162 Veranda St.  
Martial Arts Bldg.  
Choi Institute

**CITY OF PORTLAND, MAINE  
DEVELOPMENT REVIEW APPLICATION  
PLANNING DEPARTMENT PROCESSING FORM**

re: 162 Veranda Street, Choi Institute and Martial Arts

On October 20, 2000 the Portland Planning Authority approved the site plan application for the Choi Institute and Martial Arts Change of Use located at 162 Veranda Street with the following conditions:

PLANTING SCHEDULE

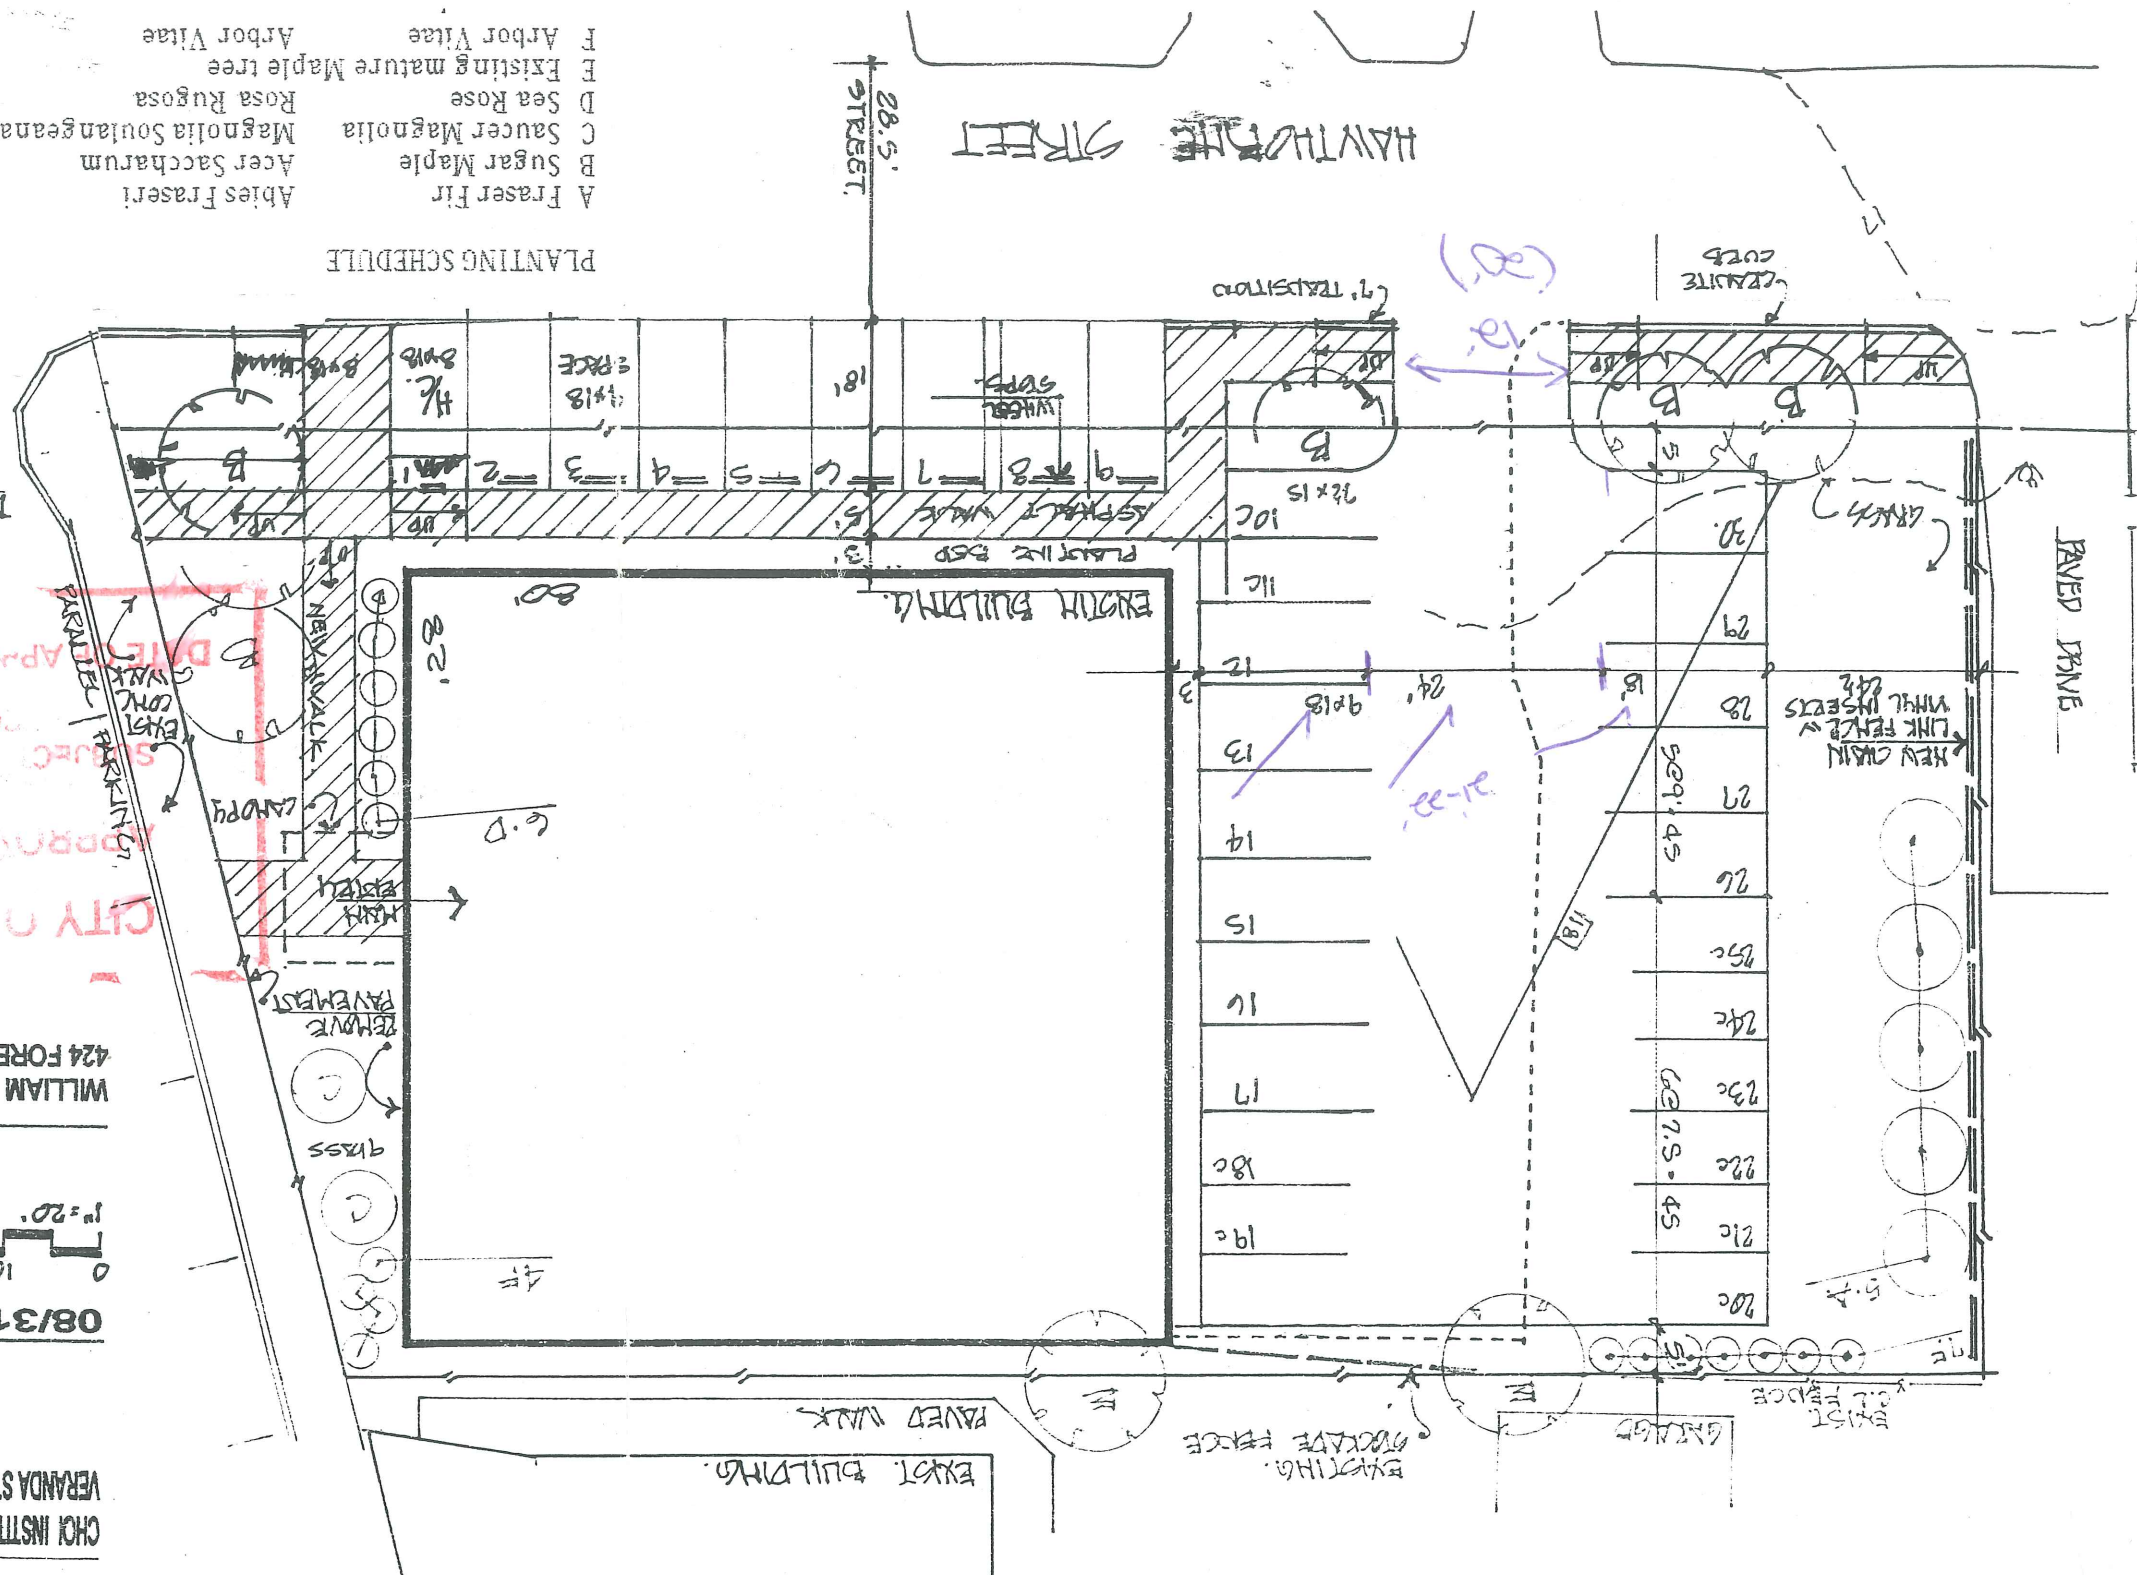
1. The asphalt sidewalk shall be built to city standards.
2. The applicant shall install an opaque fence, such as chain link with privacy slats, picket or sapling fence, not less than forty-eight inches in height between the parking lot and the westerly property line, where there is an existing residential building.
3. The applicant shall install curb stops or wooden guardrail between the parking spaces and the proposed asphalt walkway on the southerly side of the building.
4. All trees must be at least 2 ½" caliper.

**APPROVED SITE PLAN**

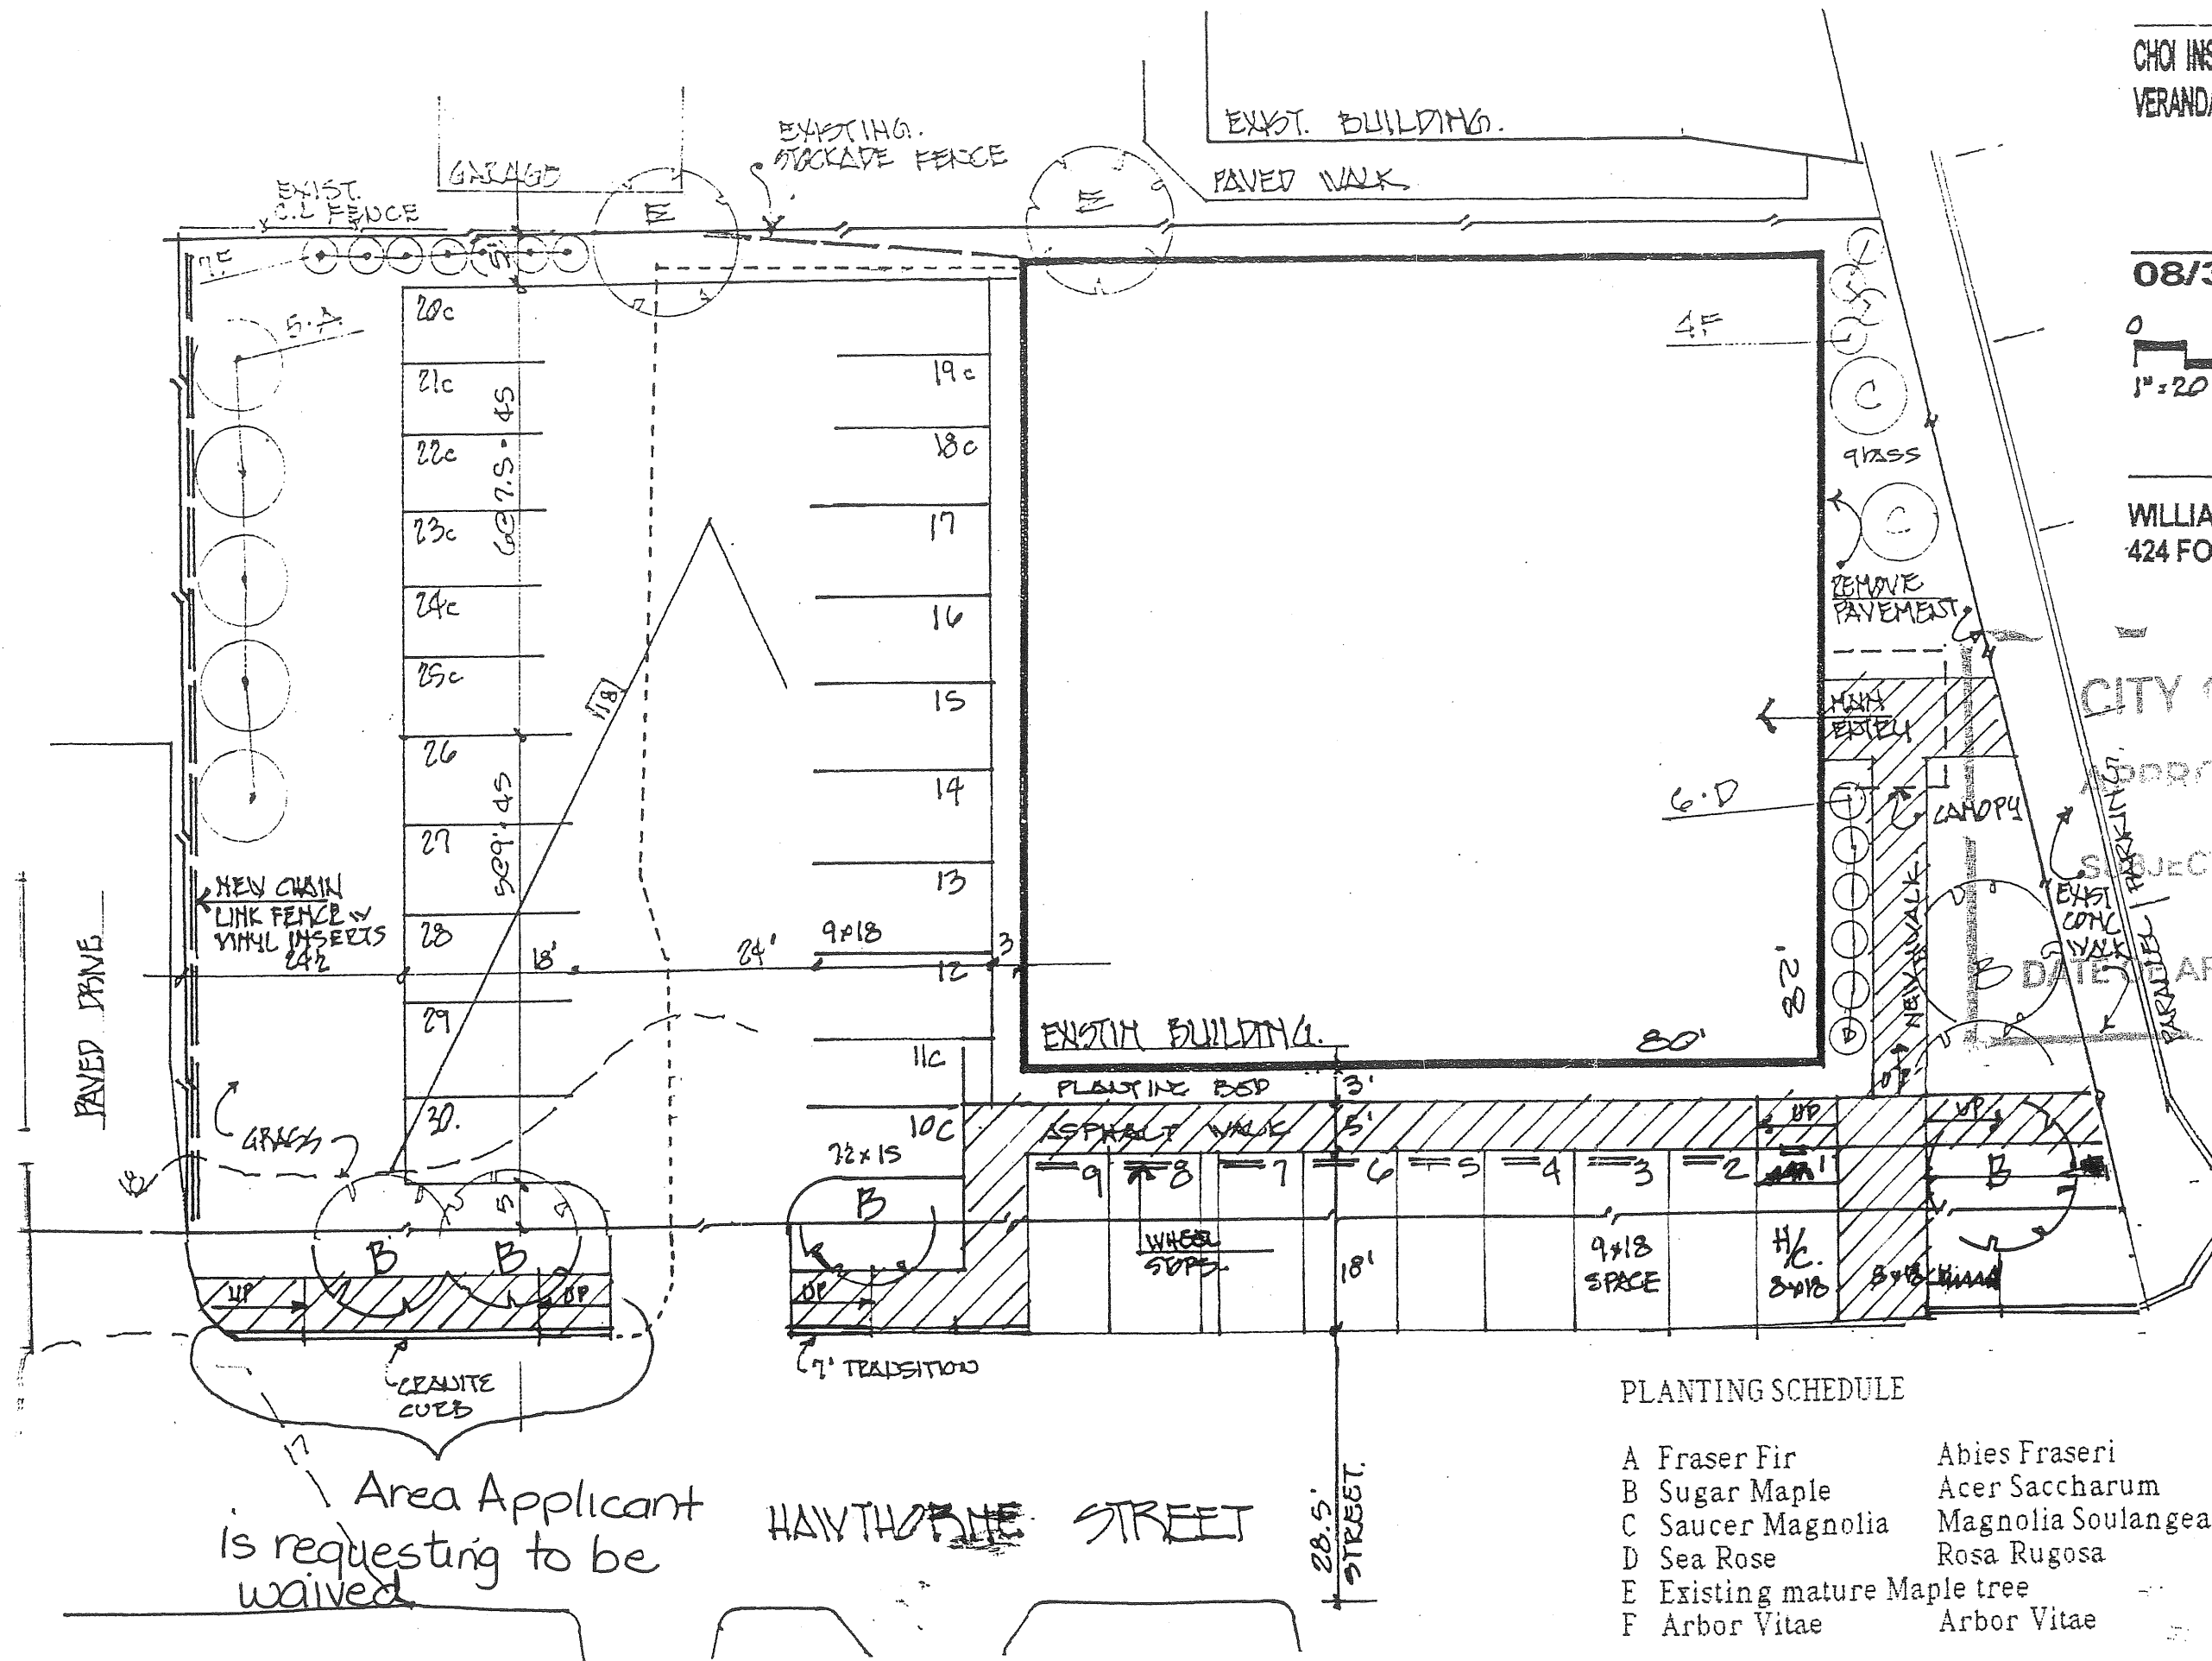
After a site visit, it was observed that the entrance to the parking lot at 162 Veranda Street does not have the sufficient width required. The approved site plan shows the entrance to the parking area at approximately 18 feet wide. The pavement and striping placement has changed the access way to approximately 12 feet wide, thus providing insufficient width for driveway access. The city requires that this item be corrected prior to issuance of a permanent certificate of occupancy and/or release of the remaining performance guarantee.

1. The building number is incorrect (# 160 is posted on the door).
2. The proposed walk is not designated, and the wheel stops in the 9 parking spaces are not installed.
3. The proposed new walk (connects the main entrance to the parking spaces) has not been built.
